DEADLINE 8 RESPONSE

KENT DOWNS AONB RESPONSE TO

**Written submission of oral comments made incorporating
additional comments, in respect of**

Issue Specific Hearing 11 – Environment Matters

*Local Landscape Character Area boundaries of the Kent Downs AONB LCA, West Kent Downs, Sub-areas Cobham and Shorne*

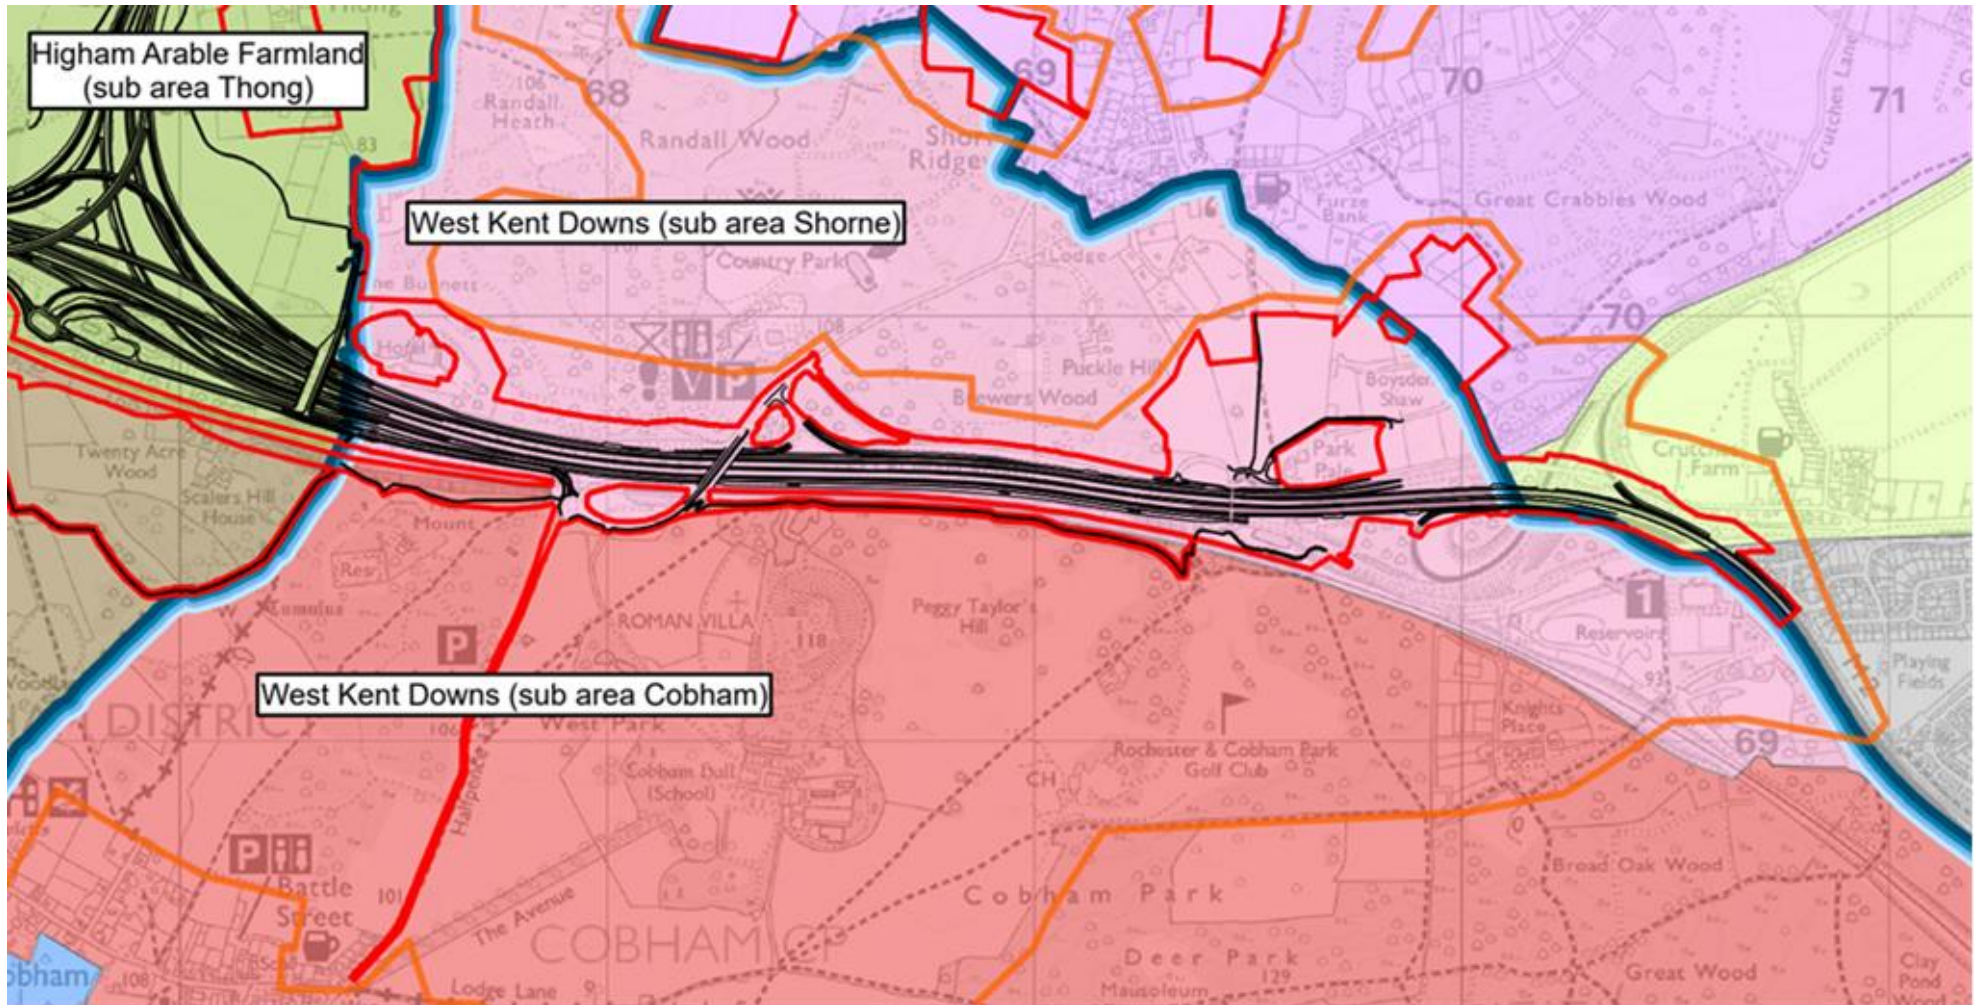
ii. The Applicant has advised in response to both ExQ1 and ExQ2 why it has 'adjusted' the boundaries for the Cobham and Shorne Local Landscape Character Areas (LLCA) for the purpose of assessing landscape impacts; however, can it explain the level of sensitivity and significance of effects it would ascribe to those areas if the boundaries had not been 'adjusted' and instead the Kent Downs AONB LLCA boundaries (which echo the Kent County Council's 2004 LCA) were used? Is there a difference?

The applicant explained that if the published boundaries had been used, then it would assess the West Kent Downs: Sub-area Cobham as Very high, rather than the High attributed to it using the adjusted boundaries, due to '*increased susceptibility to change due to vegetation loss between the HS1 and A2 corridors*'. The AONB Unit advised that it agreed with this assessment.

The applicant went on to advise that the significance of effect levels within West Kent Downs: Sub-area Cobham would be assessed as large adverse in construction, rather than moderate adverse; large adverse in opening year winter, rather than slight adverse; and moderate adverse in design year summer, rather than slight adverse, due to a greater proportion of the project being located within the local landscape character area. Again, the AONB Unit agrees that there would be an increased significance of effect if the published boundaries had been used.

In respect of the West Kent Downs: Sub-Area Shorne, the applicant stated that there would be a reduction from Very large to large during construction, and that the Operation effects reported at Year 1 and Year 15 would remain as large adverse and moderate adverse respectively. While the AONB Unit remains of the view that the Magnitude of effect for the Design Year is under-assessed in the ES and would remain large adverse at Year 15, we agree with the applicant that there would be no reduction in the reported significance of effect at operation. The AONB Unit however disagrees that there would be a reduction at Construction to large rather than Very large given the extent and nature of works that would remain in the West Kent Downs: Sub-area Shorne local character area.
